Rezoning Transportation Analysis

Petition Number: 2020-012

Revision Log:	Date	Description
	02-18-2020	First Review

SHEET NUMBER
RZ-1

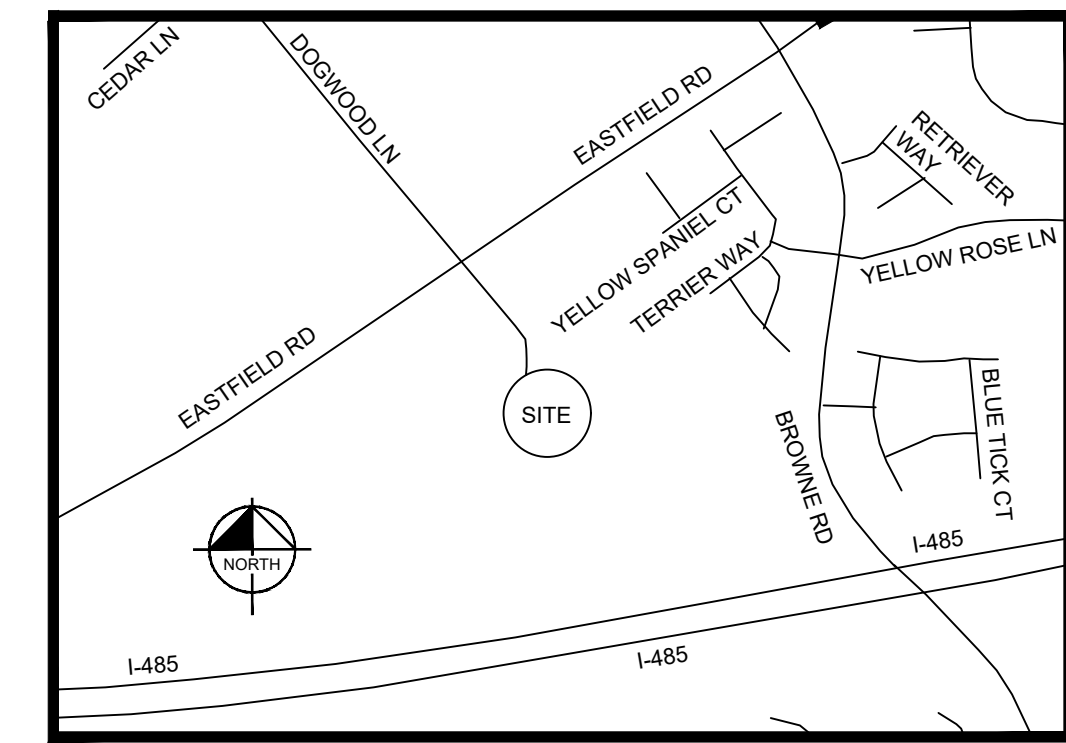
1. **Curbline** The proposed zoning district has a setback measured from back of the existing or proposed future curbline.

Eastfield Road: The future location of back of curb and gutter is 33' from centerline.

The site plan should show the curb and gutter labeled and dimensioned from the centerline for each road.

2. **Traffic Study** A Traffic Impact Study is not necessary for the complete review of this petition. If during the permitting process the site generates more than 2500 daily trips, then a traffic study will be required.
3. The petitioner should revise the site plan and conditional note(s) to commit to dedicate 40' of right-of-way from the road centerline to meet CRTPO guidelines for a minor thoroughfare. The site plan should label and dimension the right-of-way from the road centerline.
4. The petitioner should revise the site plan and conditional note(s) to extend road "B" to western property line.

5. The petitioner should revise the site plan and conditional note(s) to construct a left turn lane on Eastfield Road into Road "A".
6. The petitioner should revise the site plan and conditional note(s) to construct a left turn lane on Browne Road into Road "B".
7. CDOT is requesting the petitioner revise the site plan and conditional note(s) to create a three lane section on Road "A" where it connects to Eastfield Road as shown below.

8. The petitioner should revise the site plan to add a note specifying dedication and fee simple conveyance of all rights of way to the City before the site's first building certificate of occupancy is issued. CDOT requests right of way set at 2' behind back of sidewalk where feasible.
9. The petitioner should revise the site plan to add a note specifying all transportation improvements will be approved and constructed before the site's first building certificate of occupancy is issued. The petitioner may phase transportation improvements if said improvements and phasing are explicitly described in site plan notes.
10. ~~Resolved-Sample format for comment that is resolved~~
